Submission regarding The Northern Road upgrade – Mersy Road to Glenmore Parkway.
submitted by Luddenham Progress Association

Point 1: We object to the proposal published in August 2018 to install traffic signals at Adams Road/The Northern Road. The reasons are as follows.

Figure 1-1 | Overview of proposed changes to Stage 6 of the project

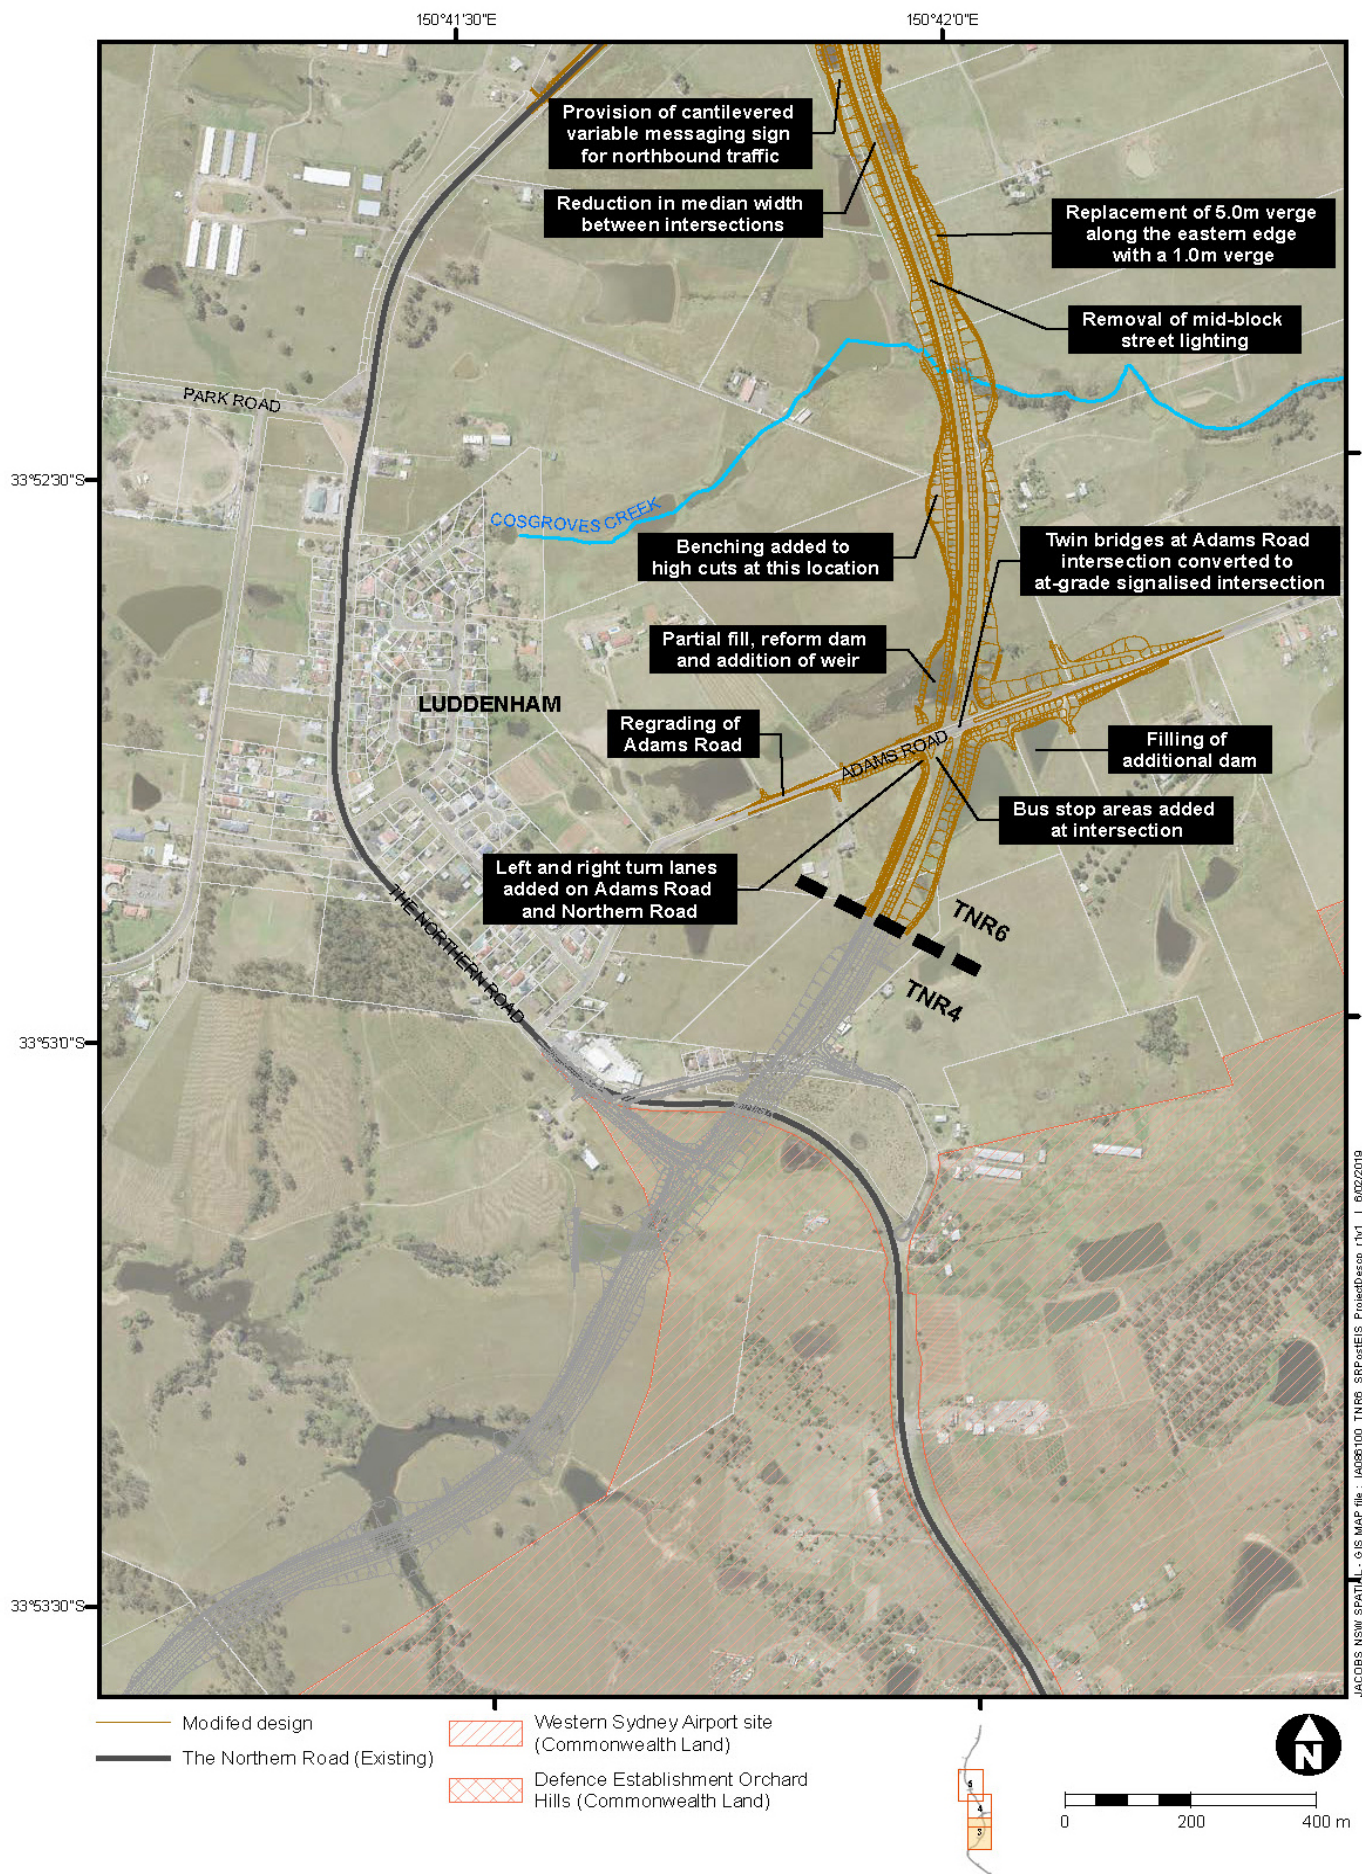
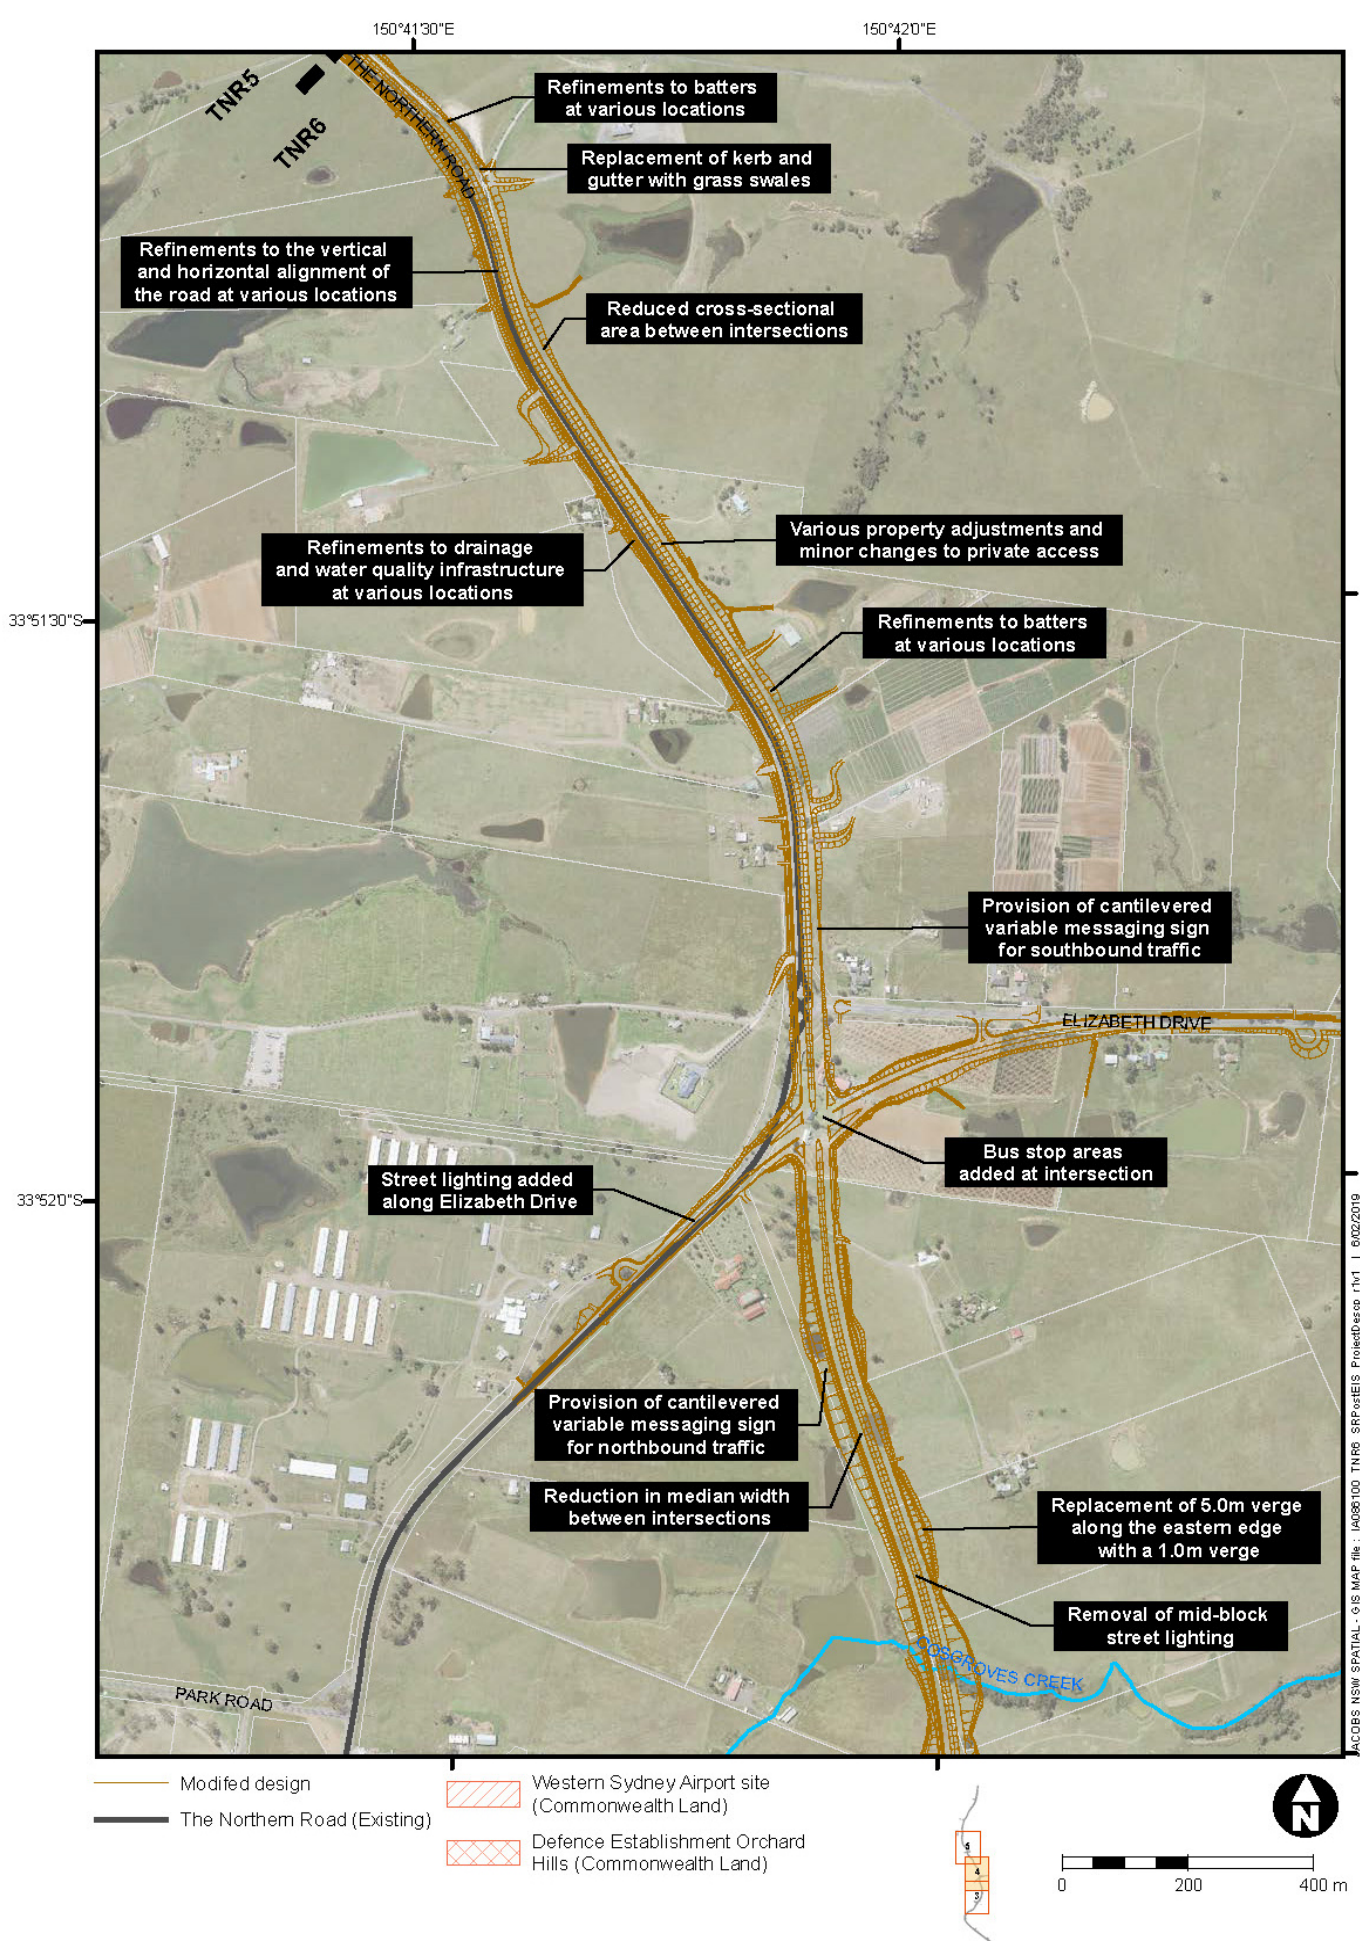
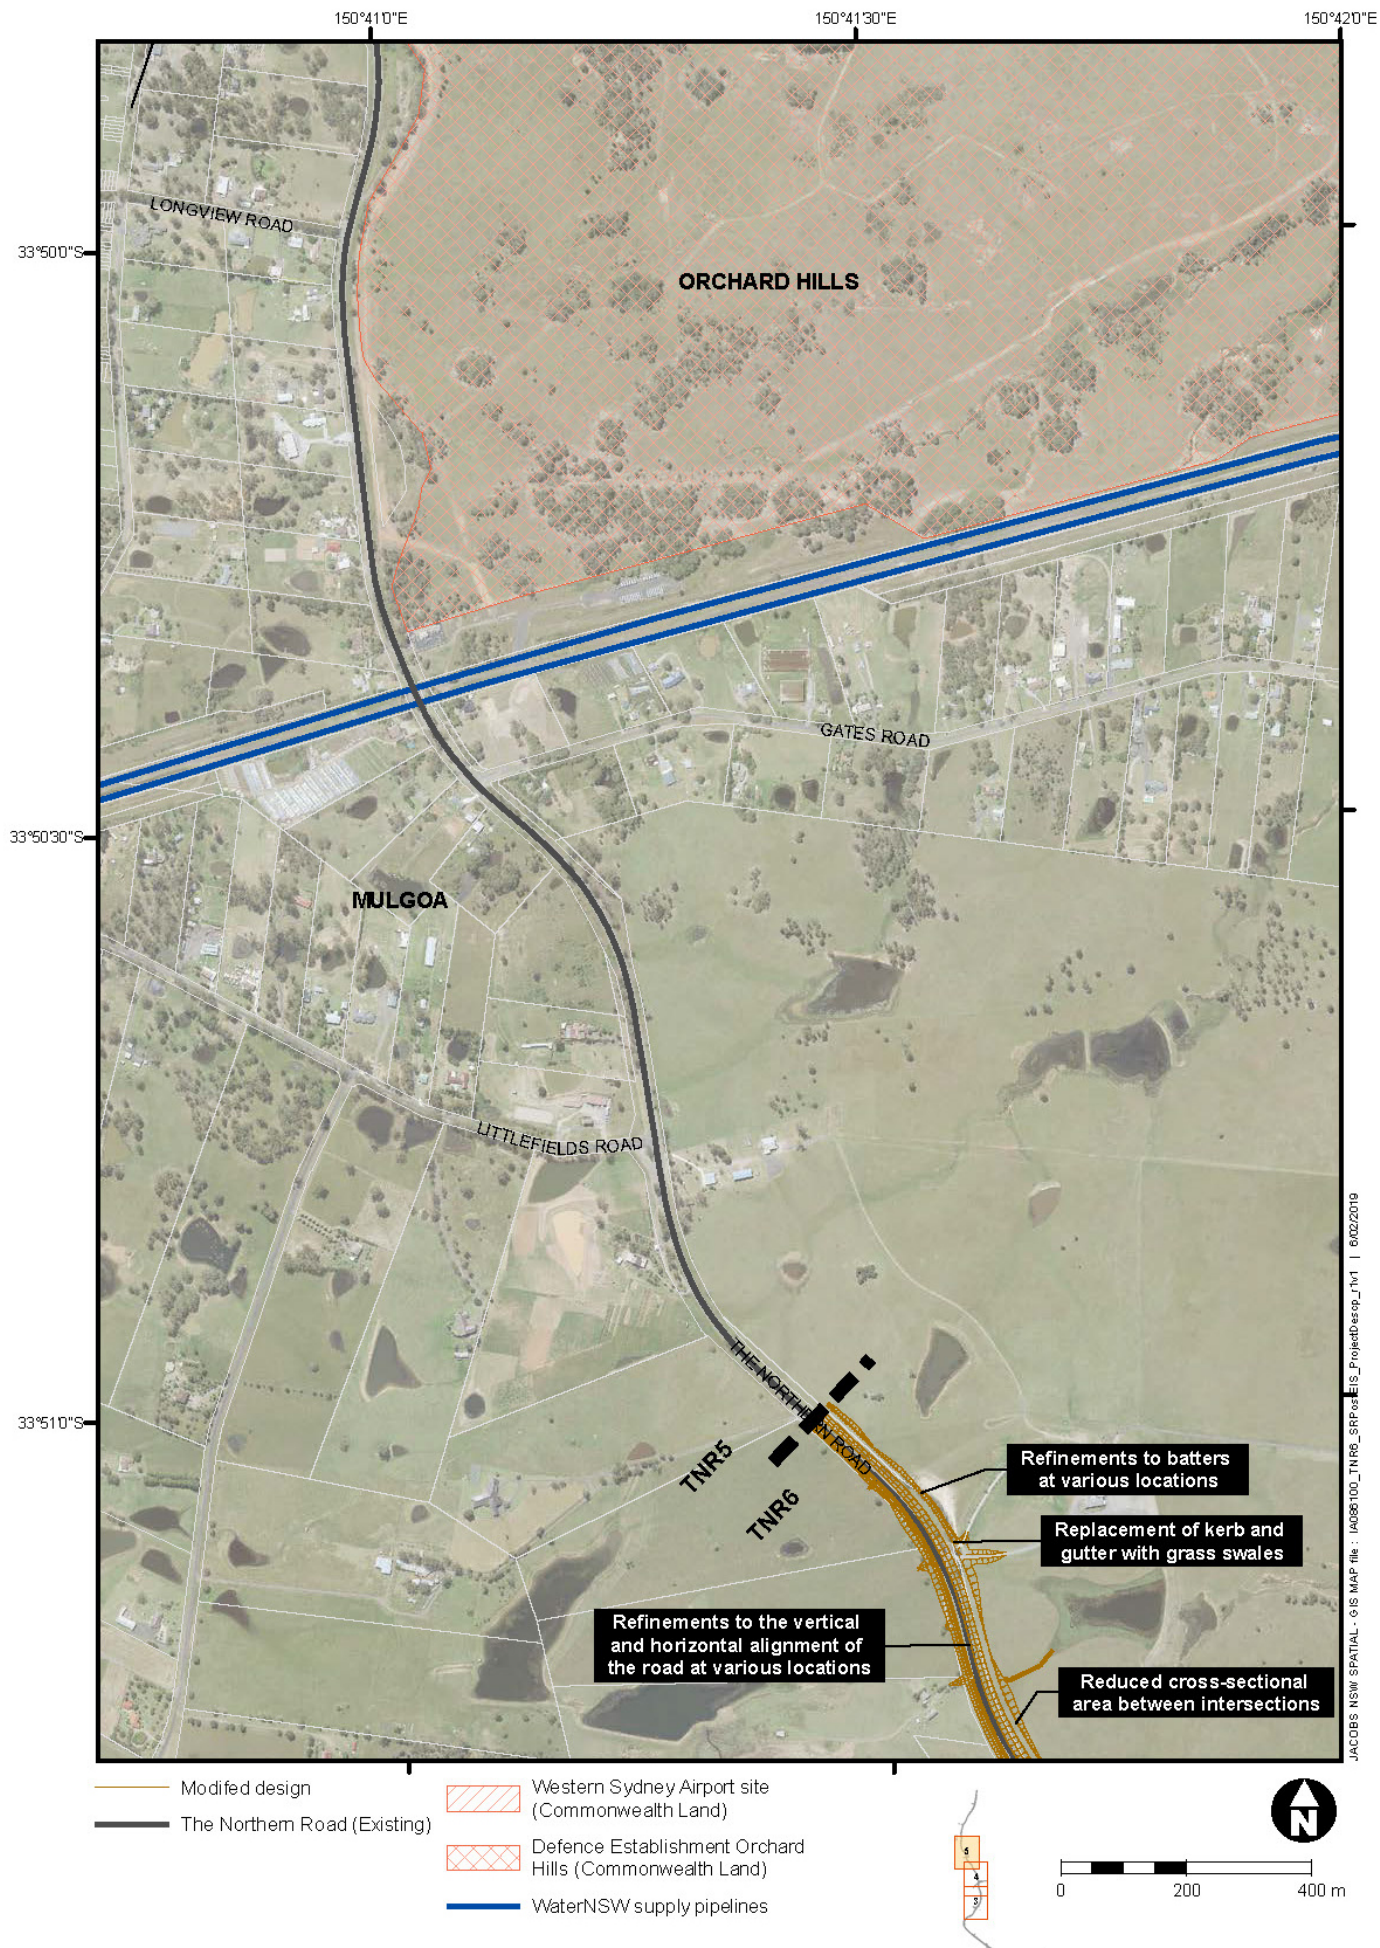
- e) We do not see that building the agreed bridge over Adams road will have any more impact on property acquisitions than that of the suggested traffic light intersection, the same amount of land will be required in both cases.

- g) Having the bridge over Adams road to carry the diverted The Northern Road will have no impact on travel times on either the diverted The Northern Road or Adams road. On the other hand placing traffic lights at the diverted The Northern Road/Adams road intersection will cause delays on both

Point 2: We object to the Eaton Road (west of the alignment) now being restricted to be "Left in, left out only. It seems, although not documented as far as we can see, there will be a medium strip placed in the centre of the existing The Northern Road as it approached the diverted The Northern Road so forcing all traffic at the western end of Eaton road to have to turn left. This makes no sense, there is no median strip on The Northern Road now and as the exiting The Northern Road becomes a quiet side road where it approaches the traffic lights at the diverted The Northern Road we can see no reason to add a medium strip at this juncture. In addition, Eaton road, (west of the new alignment) is only some 200 metres or so from the shopping centre, the post office and the medical centre and it comes across as utter blind bureaucratic nonsense to expect people to travel extra kilometres just to get to their local services.
